**Our ref:** WA/2021/129425/01-L01  
**Your ref:** 21/03558/OUT  
**Date:** 19 January 2022

**Residential development for up to 250 dwellings including affordable housing and ancillary uses including retained local wildlife site, public open space, play areas, localised land remodelling, compensatory flood storage, structural planting and access**

**Land on the north east side of, Gavray Drive, Bicester**

(see Drawing No. 239\_P11-Access & Movement Parameter Plan)

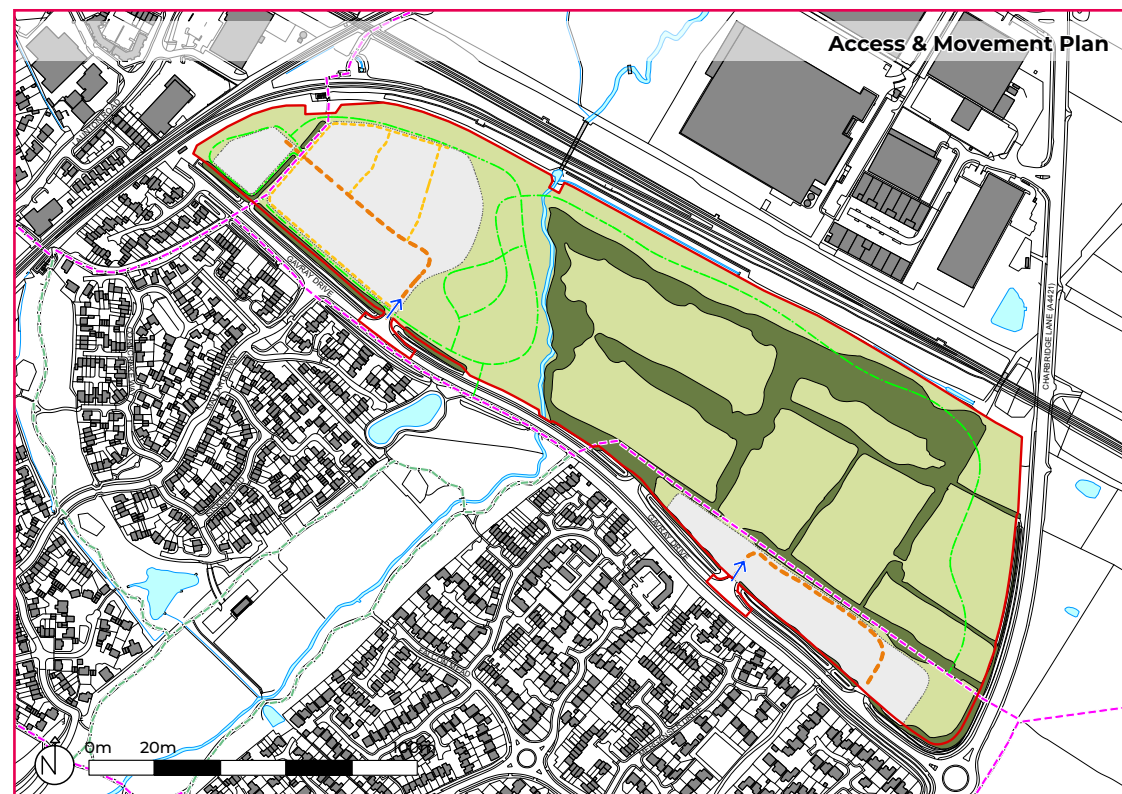
2. Apply the sequential approach to locating development in the lowest flood risk area. The FRA confirms that some of the residential units and vehicular access will be located within flood zone 3a and within an area identified at future flood risk due to climate change.
3. Flood risk mitigation measures to address the loss of flood storage as a result of residential development and vehicular access within an area of flood risk are inadequate because they will increase the risk of flooding. The proposed flood storage compensation scheme is not designed to Environment Agency standards.

The FRA states that some residential parcels and vehicular access is located within flood risk zones. This is contrary to policy Bicester 13 which requires the sequential approach to ensure all development is located outside of Flood Zone 3. The proposed mitigation for the loss of flood storage resulting from this is through volumetric compensation. The proposed area for this compensation is within land which is already at risk of flooding and therefore will be provide the level for level mitigation required. The FRA is also lacking in how much flood storage is lost and how much will be gained.

TITLE
CUT AND FILL STRATEGY SHEET 1 (WESTERN DEVELOPMENT)

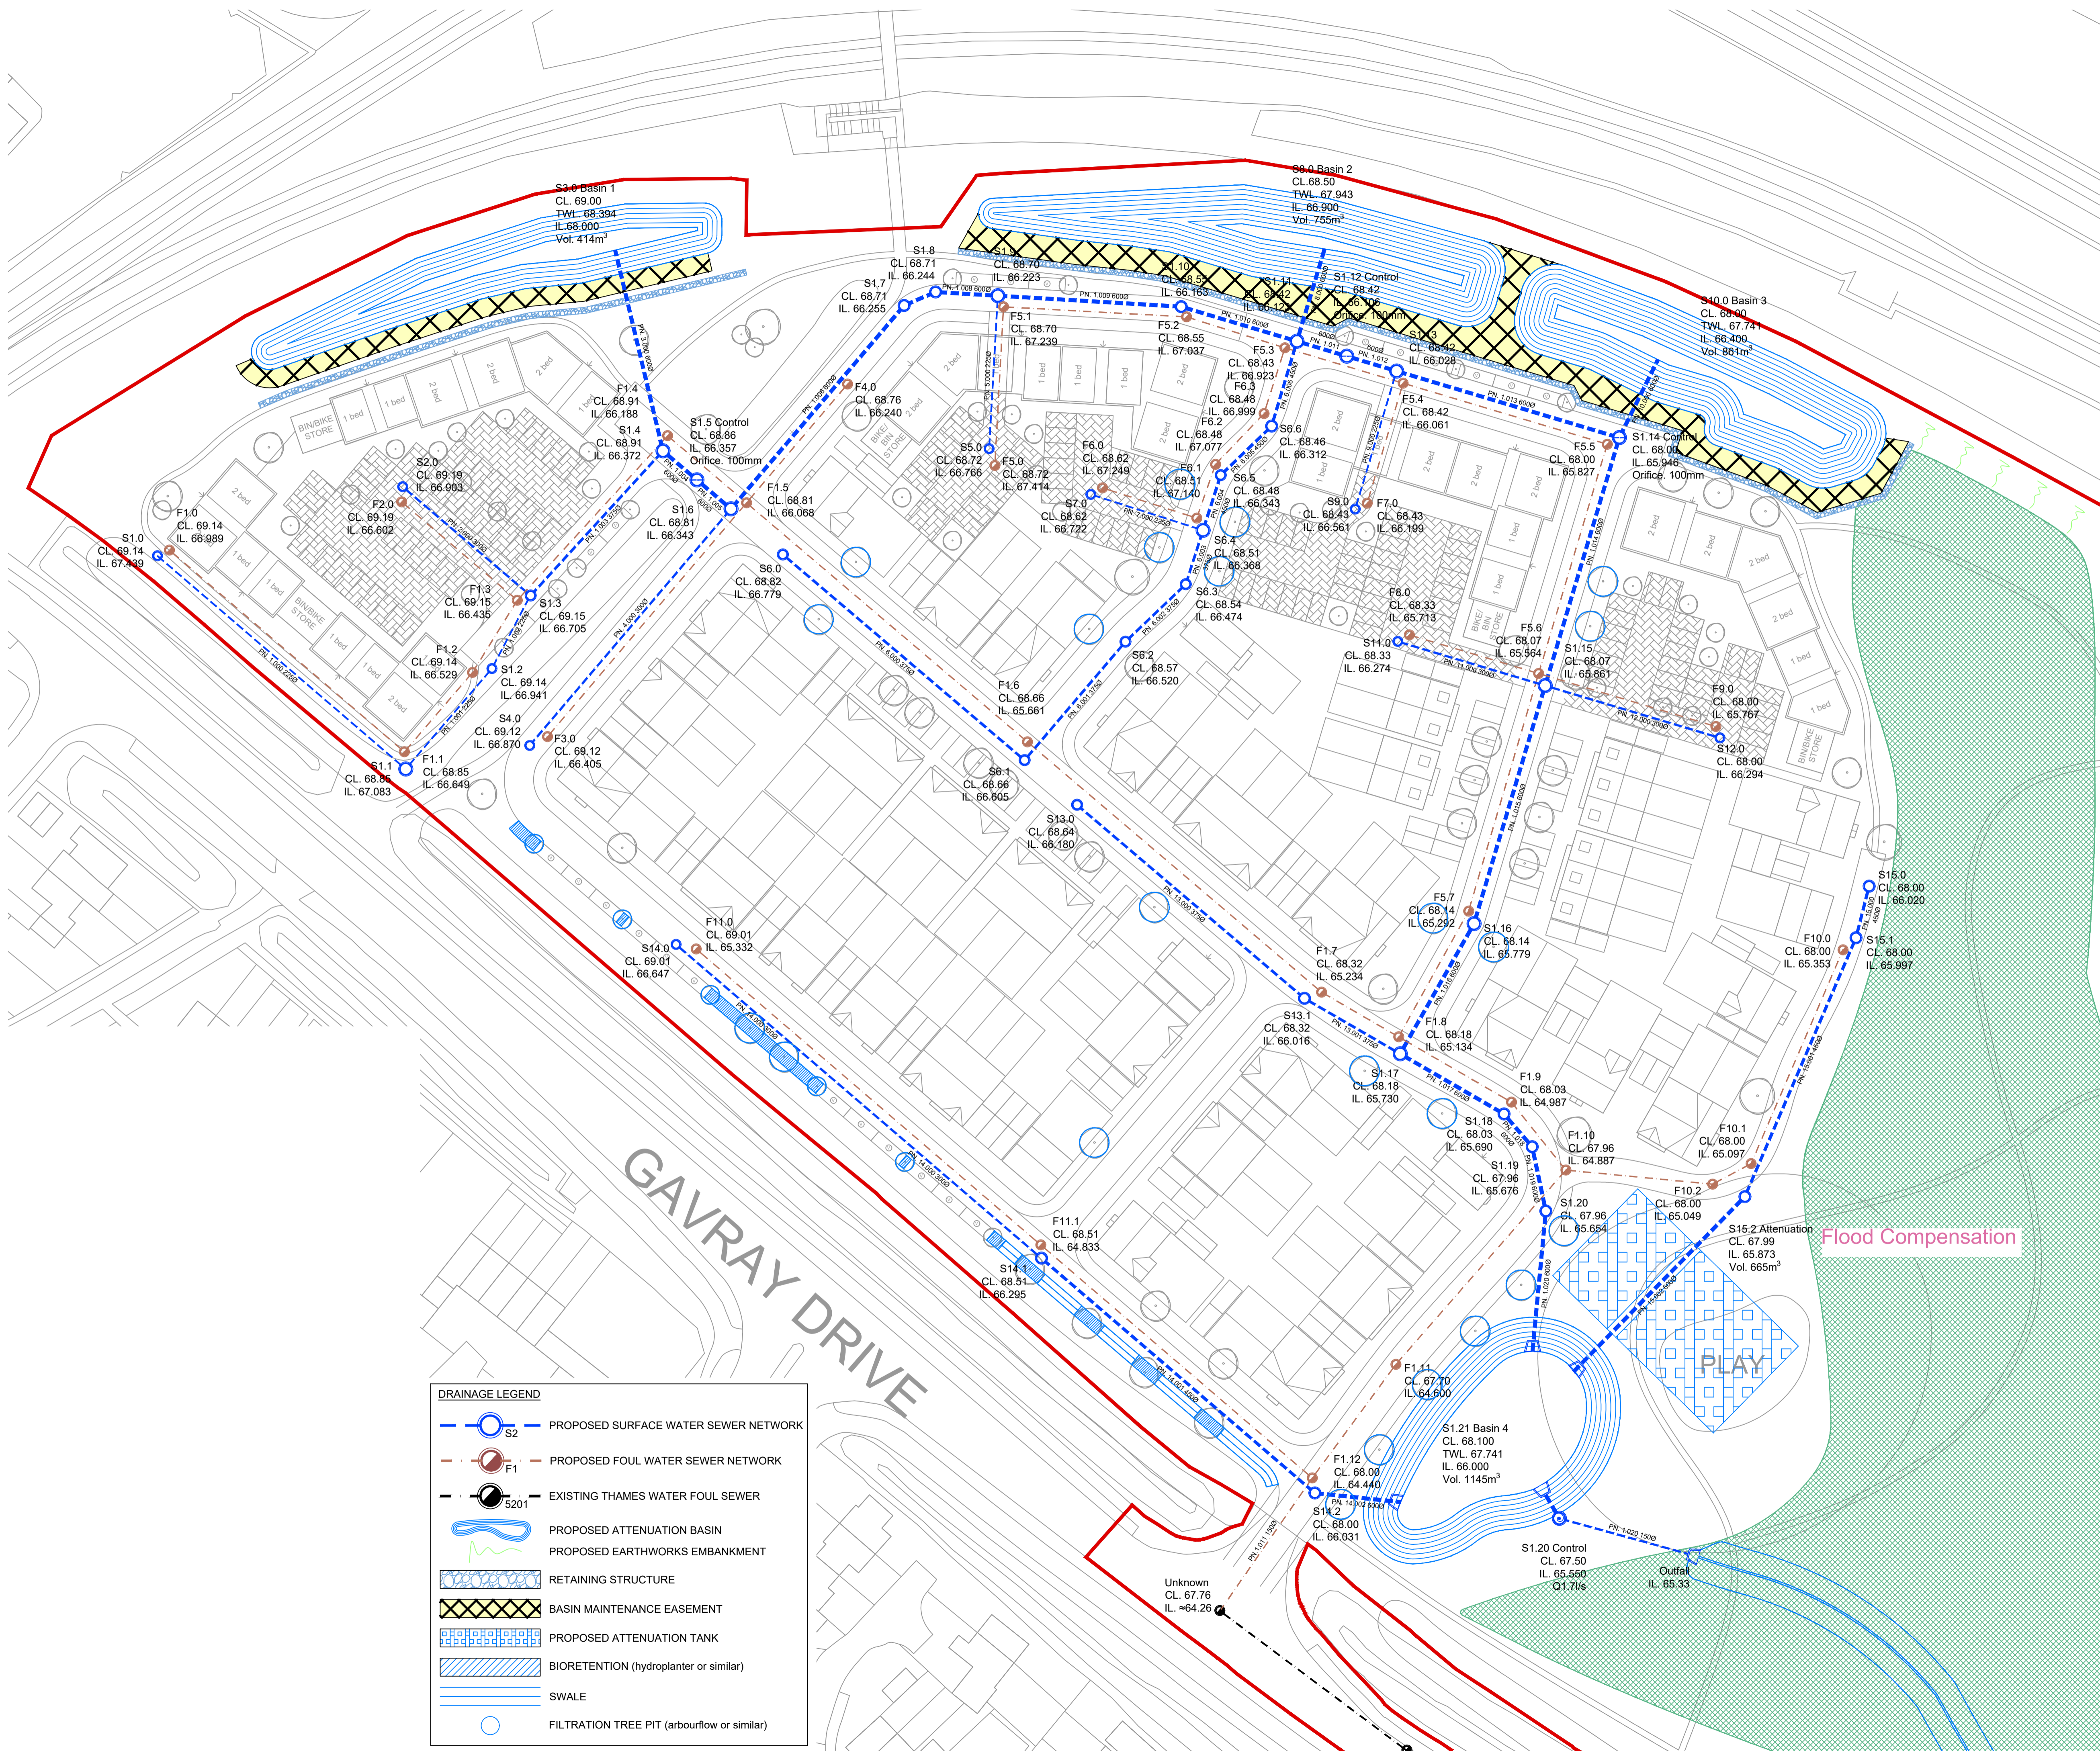
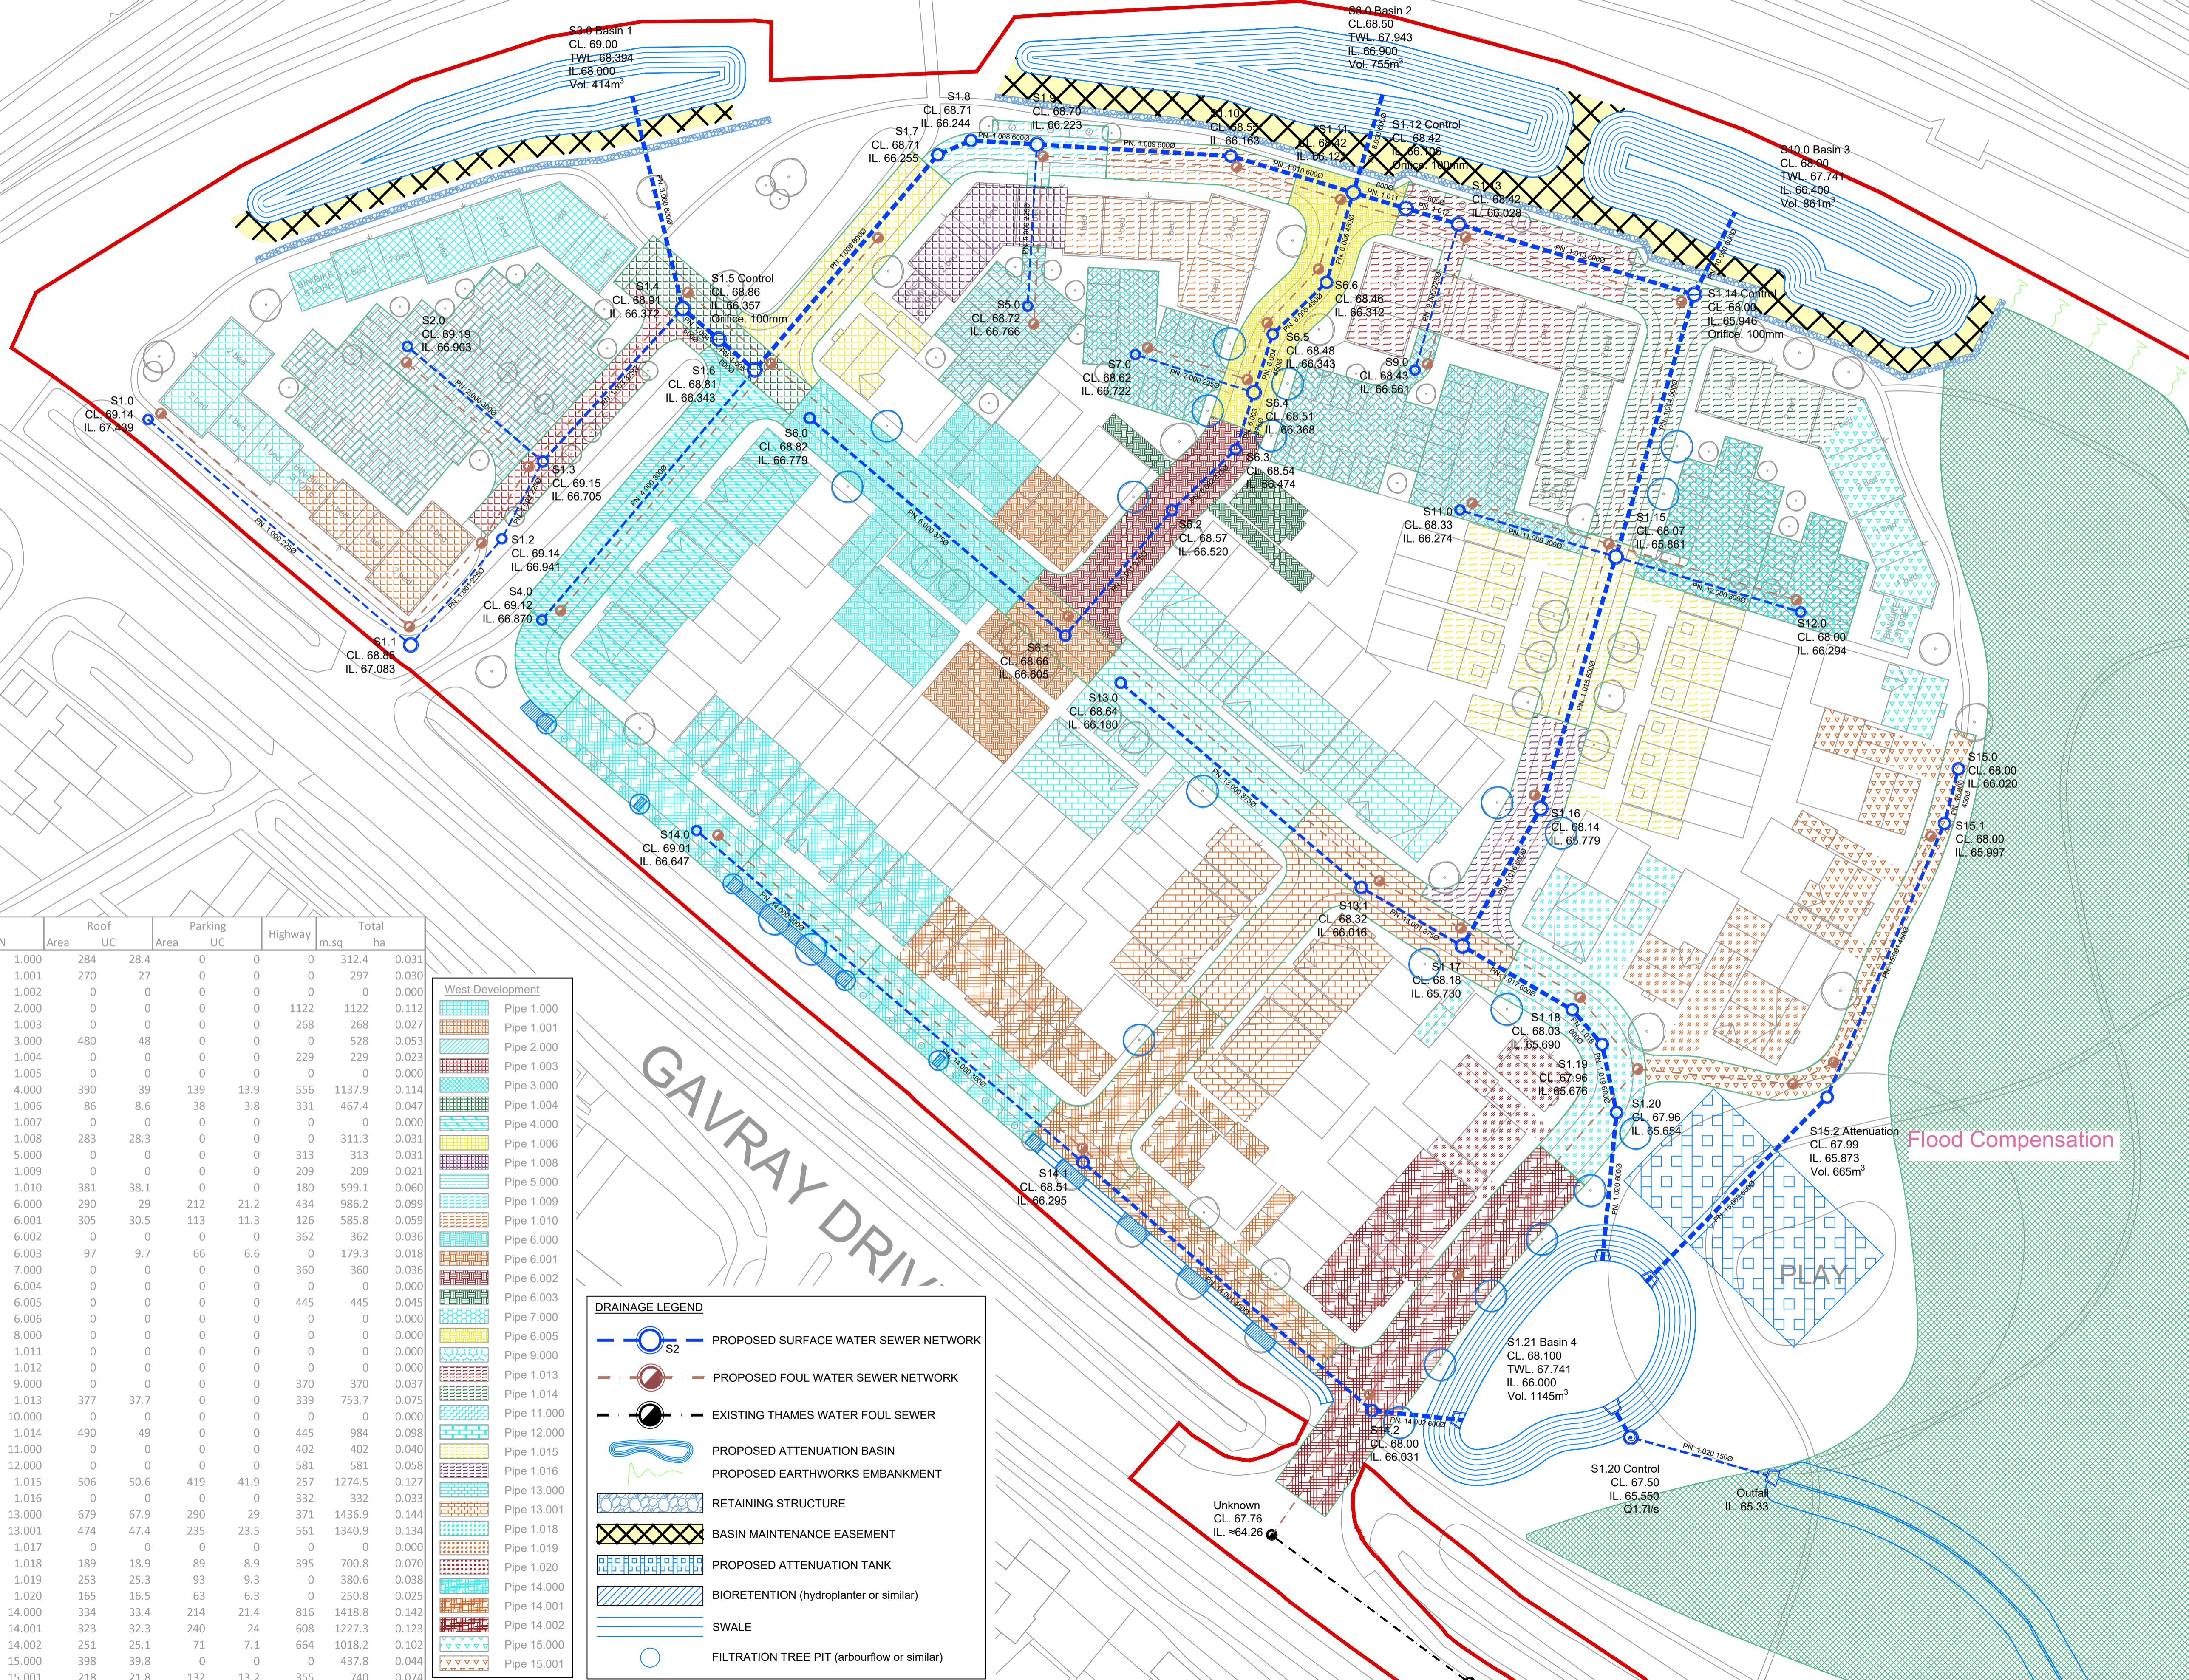
Any loss of floodplain storage, as a result of development, within the 1% annual probability flood extent with an appropriate allowance for climate change (1% plus climate change) must be directly compensated for. This is necessary to prevent the new development reducing flood plain storage and displacing flood waters, thereby increasing flood risk elsewhere.

Level for level flood plain compensation is the preferred method of mitigation. This method is the matching of volumes lost to the flood plain with new flood plain volume through the reduction of ground levels. For this to be achievable it requires land to be available to the applicant on the edge of the flood plain and above the 1% plus climate change flood level. Comparing the flood level with a topographical survey will show the availability of suitable land.
